MECKLENBURG COUNTY  
Park and Recreation Department

MEMORANDUM

**RE:** Rezoning Petition #2022-045  
PID# 15703417

SCHEMATIC SITE PLAN

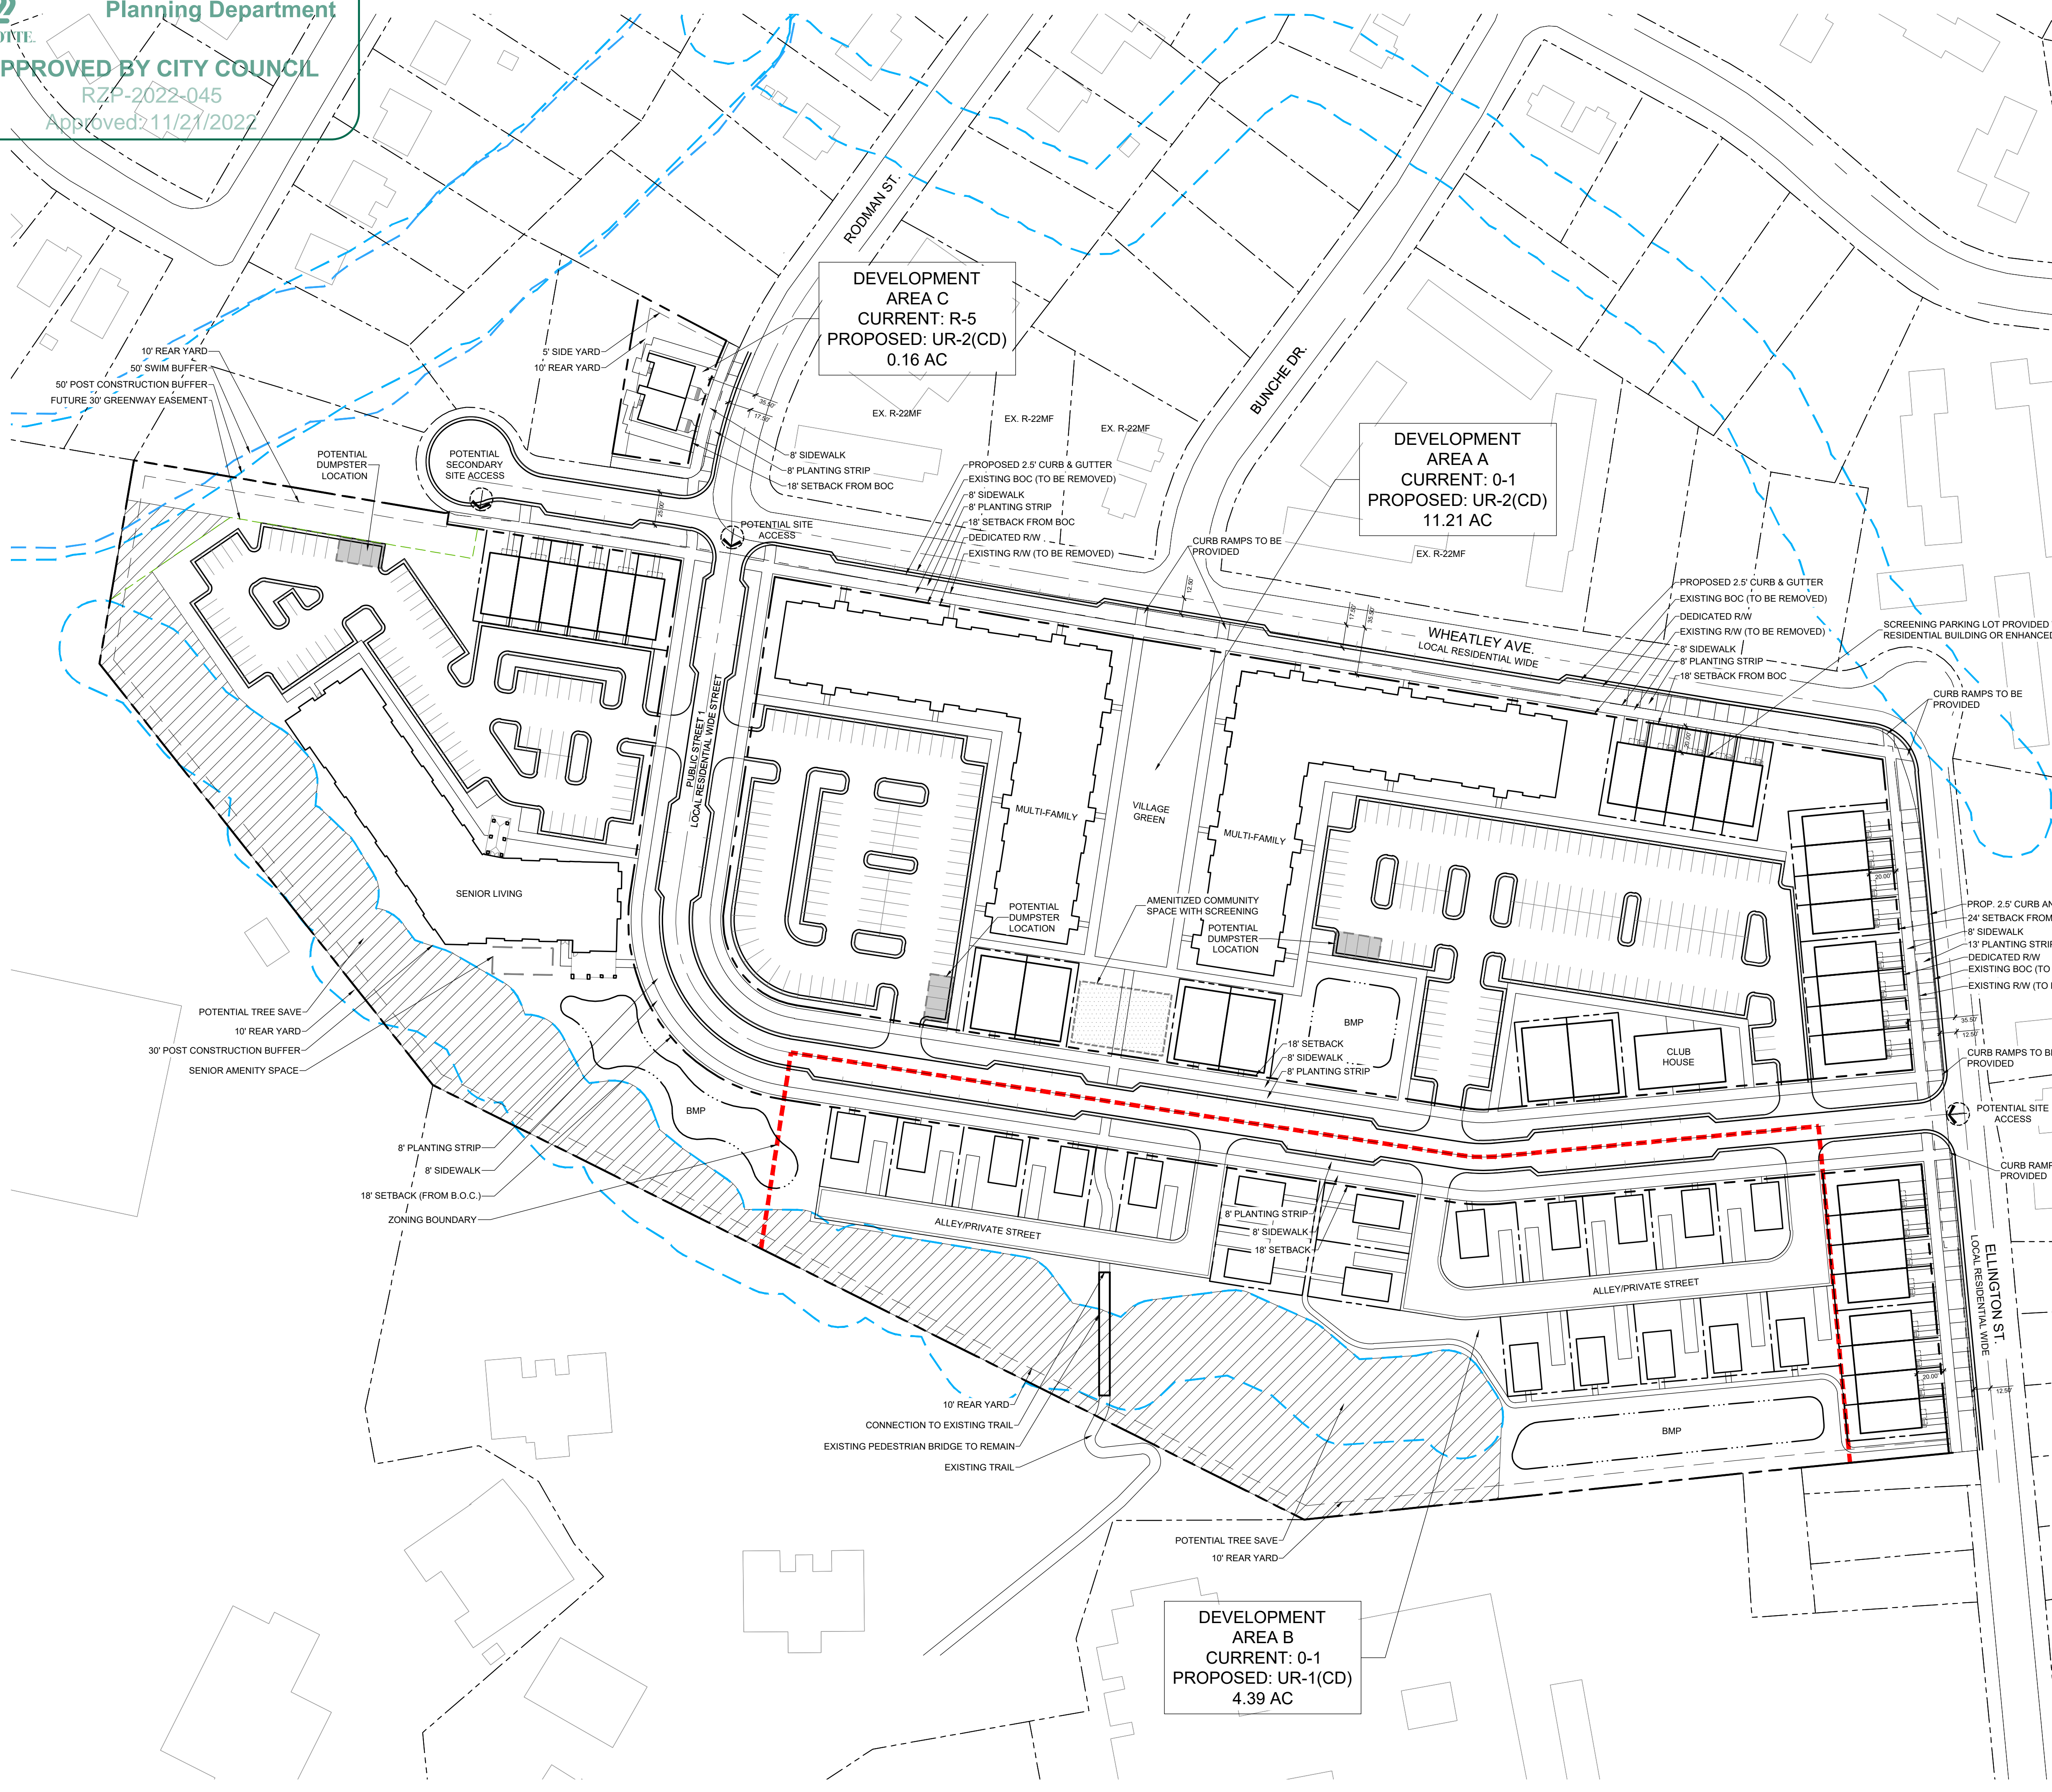
Per previous coordination with Mecklenburg County Park and Recreation, provide a pedestrian connection between the development and Randolph Road and Grier Heights Park via a sidewalk along Wheatley Ave in addition to parkland dedication or trail easement for a trail connection between the Wheatley Ave ROW and the western property line shared with Mecklenburg County. Reference markups in Plan Room.
